## **SSD 6952 - New Education Building at Wenona School – Submission & Objection**

Uniting Church Property Trust (*Uniting*) is the property owner of *Georgian House* 52 McLaren Street, North Sydney. Further to our telecon of 15<sup>th</sup> October 2015, we provide our objection to the subject development application at Wenona School. We recognise that our submission is provided after the exhibition period closed on 28th August 2015. We respectfully request that the proponent, the department and the assessment panel gives appropriate consideration to the matters raised in our submission. Our submission is in regards the built form of the proposed building on the boundary adjoining Uniting's land.

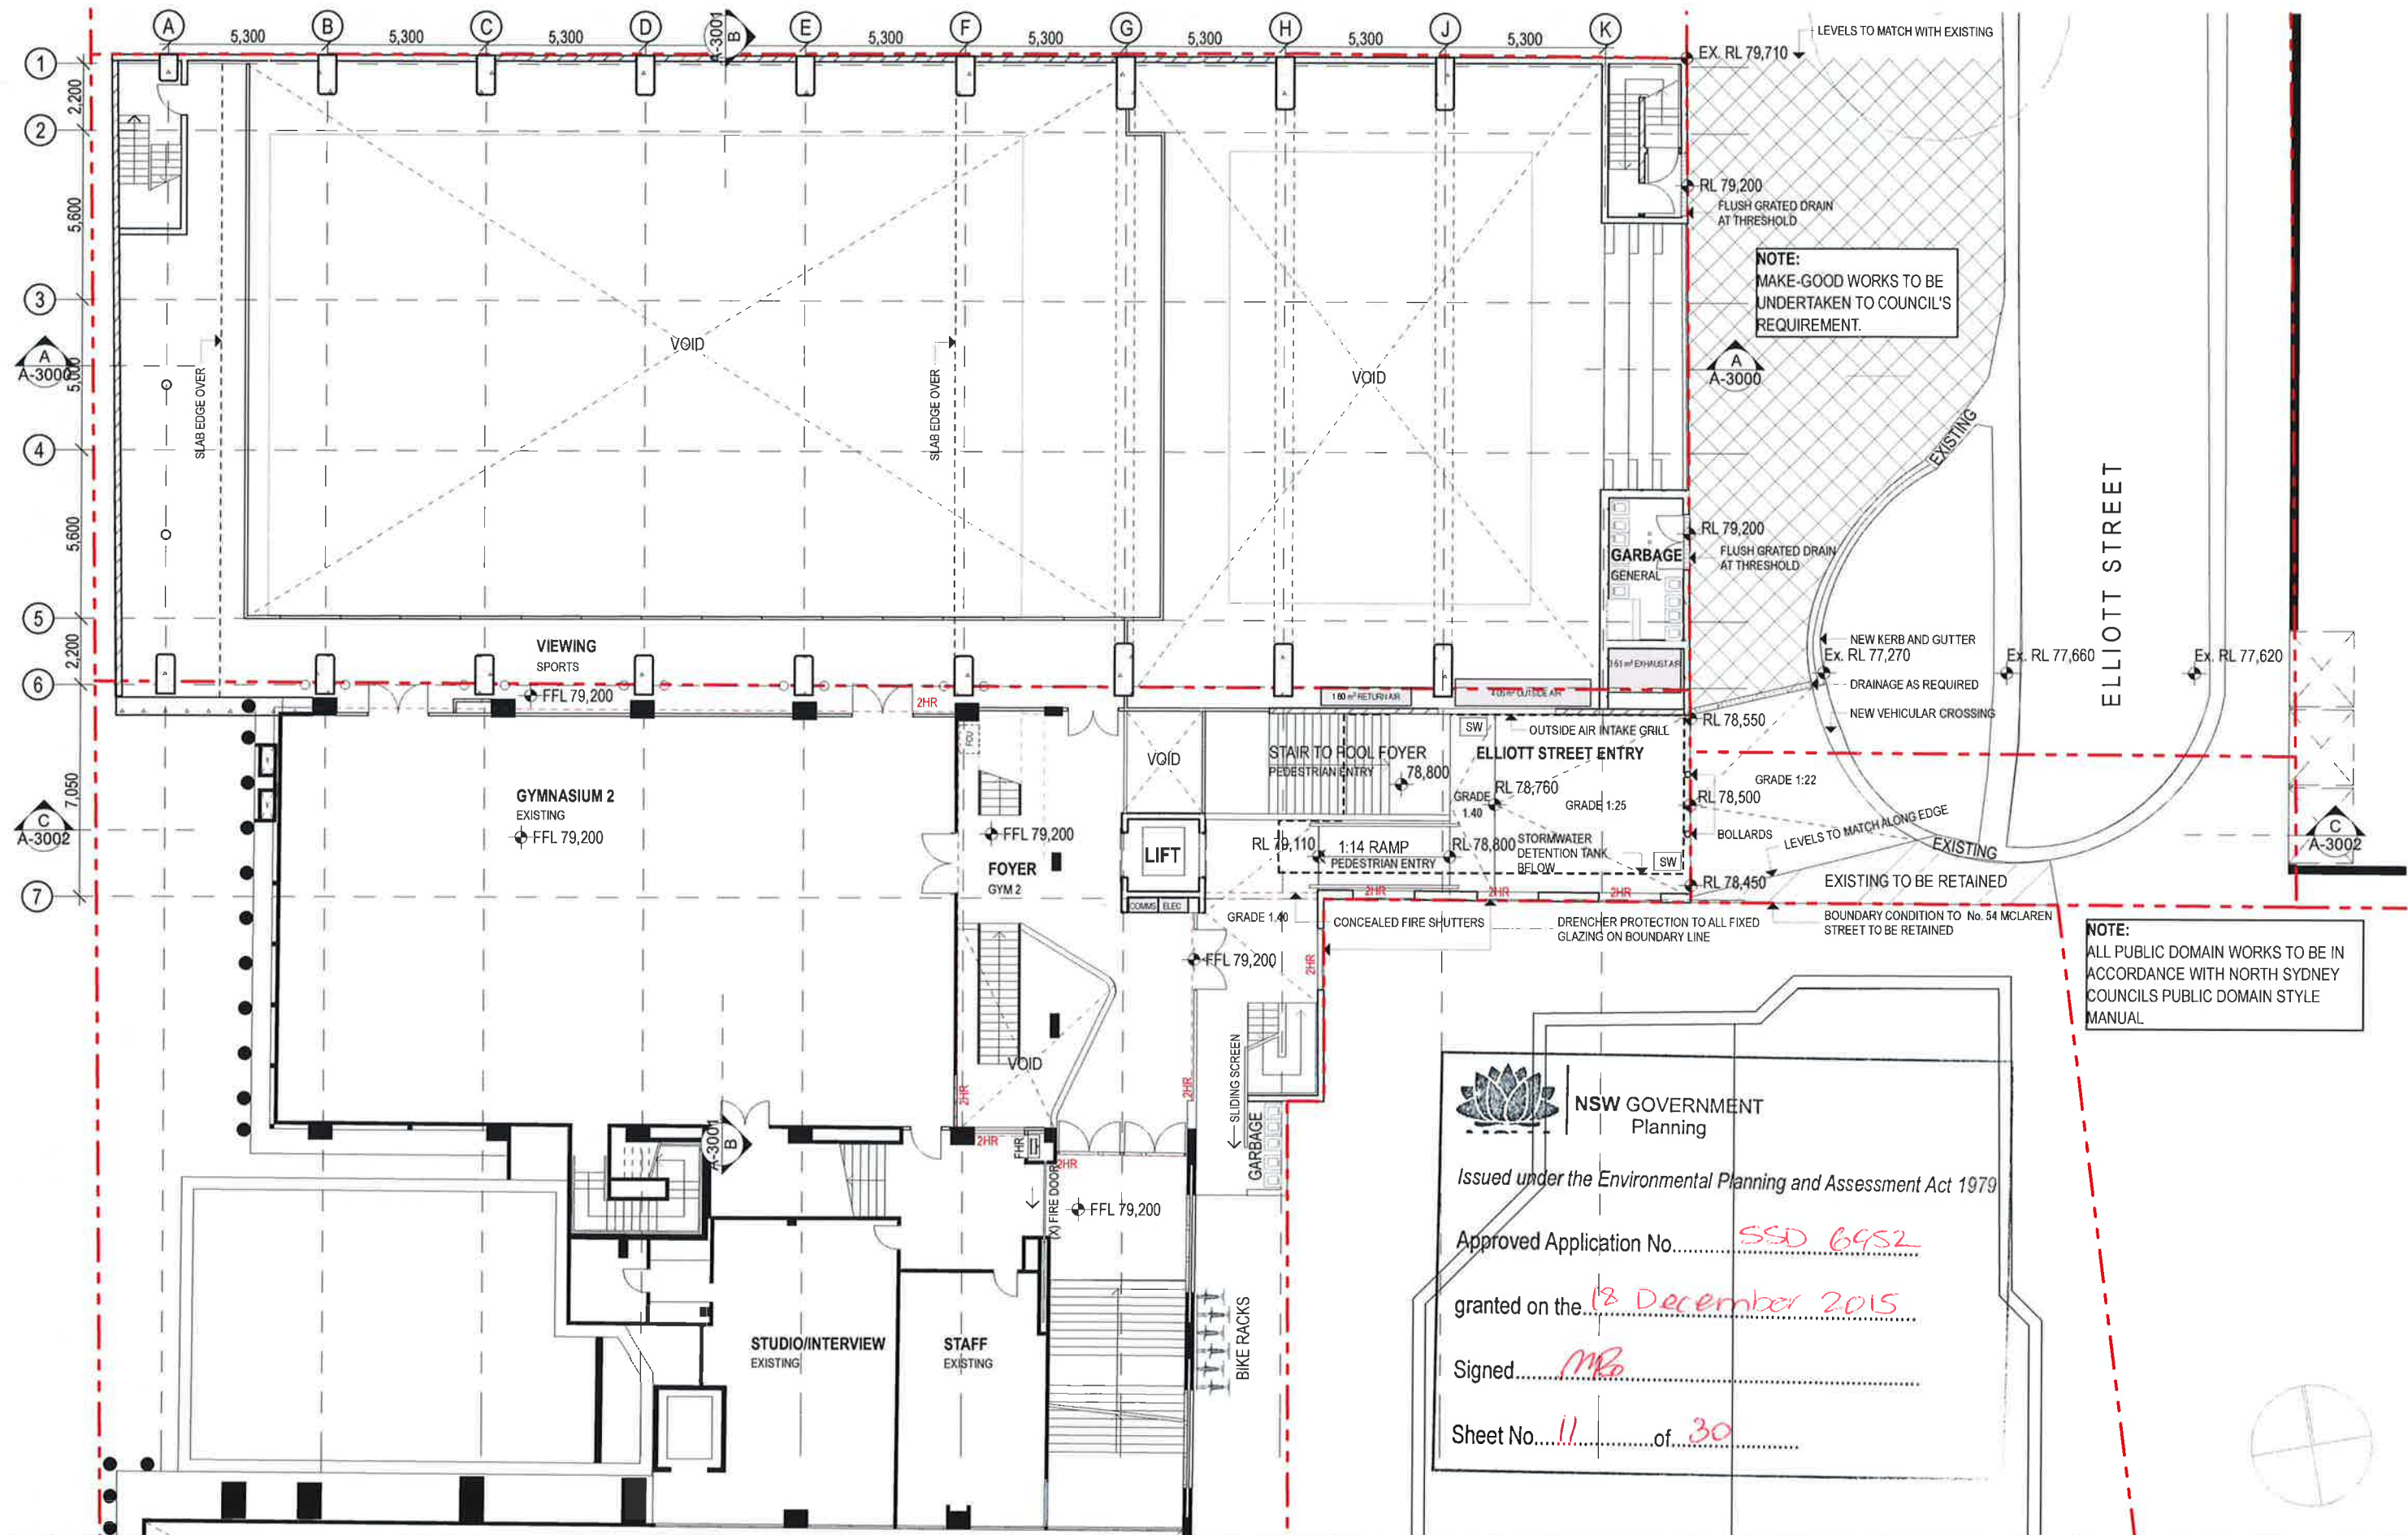
Wenona School proposes to build its new facility on the boundary line with our land, three to four levels above ground at Elliot St.

The *North Sydney Development Control Plan 2013* (Part B Section 2.4.3, P6 to P10) states that '*... buildings containing non-residential activities (i.e. Wenona School) must have a set-back a minimum of 3m from the property boundary where adjoining site has balconies or windows to main living areas of dwellings ... located at the same level ...*'. It further provides controls for building height plane requirements (P7).

- there are existing resident rooms facing the boundary with Wenona School which are main living areas and
- we provide residential type accommodation and it is likely that with a redevelopment we would have residential spaces with balconies or windows to main living areas of dwellings located at the same level and facing the boundary.

We request that consideration be given to applying the boundary set-back between the adjoining lands of Wenona School and Uniting as stated in the *North Sydney Development Control Plan* in providing a satisfactory boundary interface between non-residential and residential uses.
